Our Ref: AW/206/18/PL

**Town & Country Planning Act 1990 (as amended)
Town and Country Planning (Development Management Procedure) (England) Order 2015
Application for Planning Permission**

Development Rear extension to provide an additional bedroom with a larger first floor balcony. Removal of brick entrance pier & 2 adjacent trees at front - This application may affect the setting of the Craigweil House, Aldwick Conservation Area

Location The Boathouse 14 Craigweil Manor Aldwick

SITE PLAN - AS PROPOSED

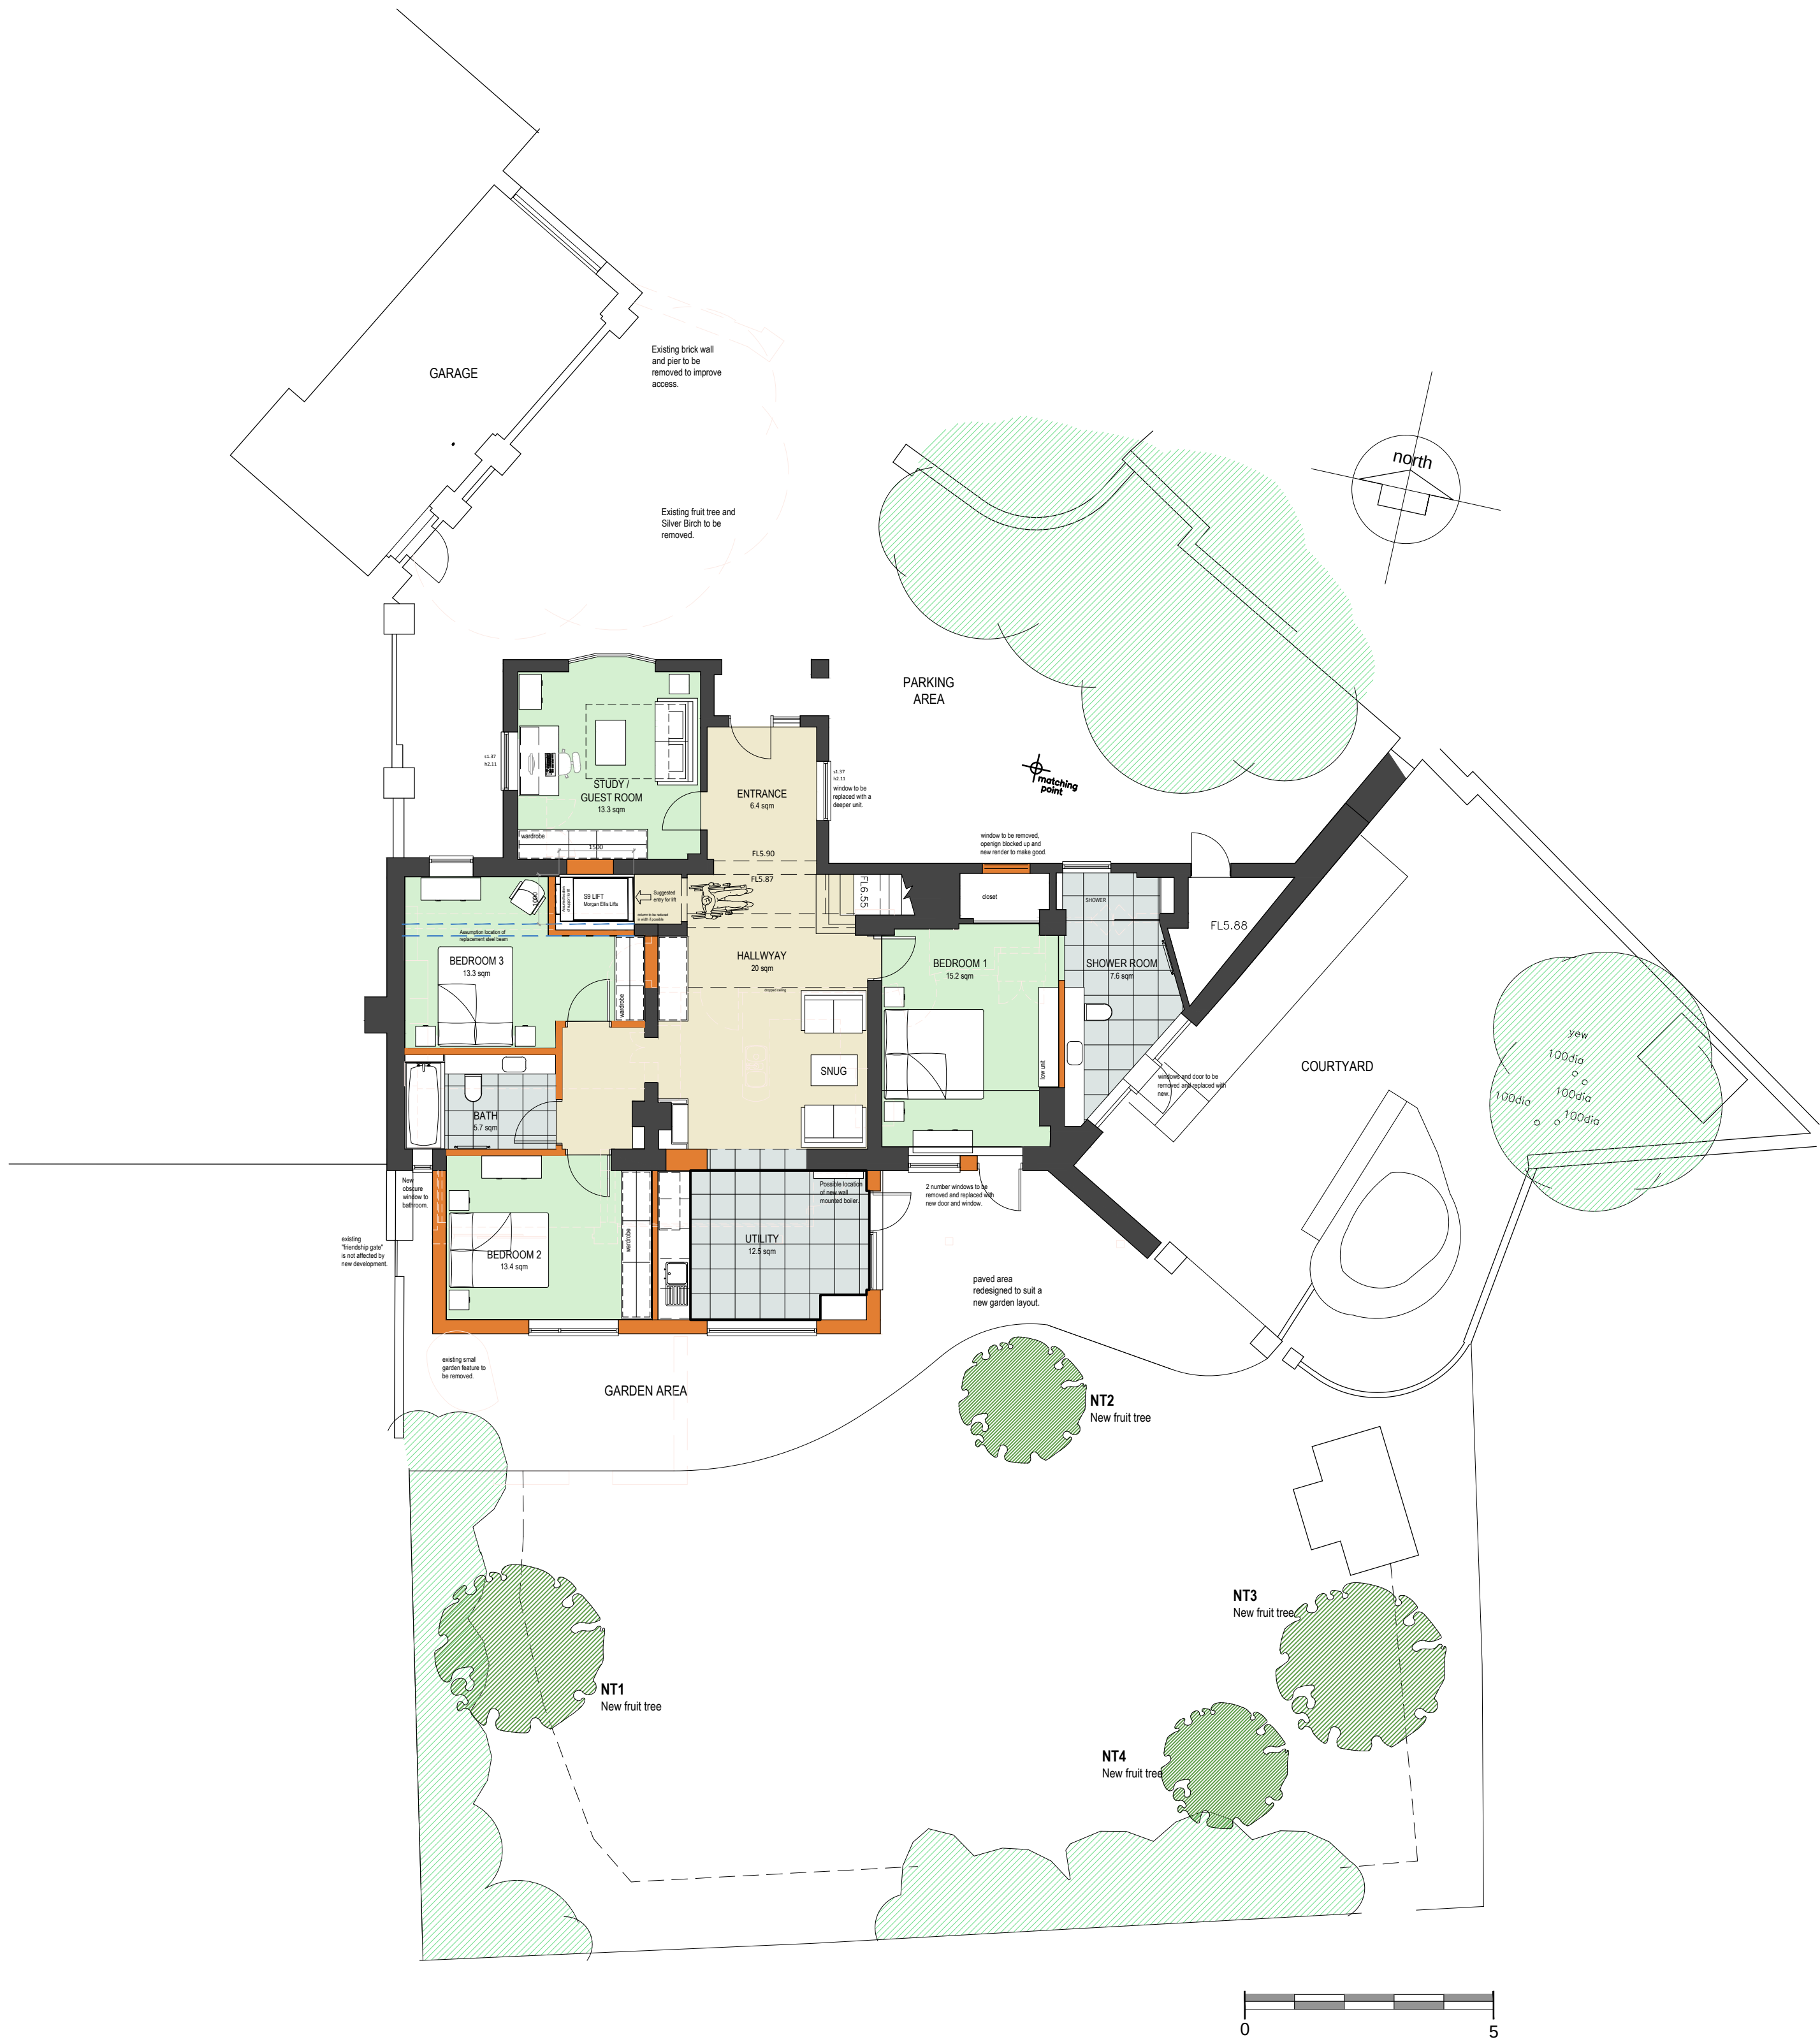
Block Plan

Please submit 1 electronic or 3 paper copies of an amended block/site plan at a scale of 1:500 or 1:200 clearly showing the proposed works clearly highlighted together with measurements to the boundaries.
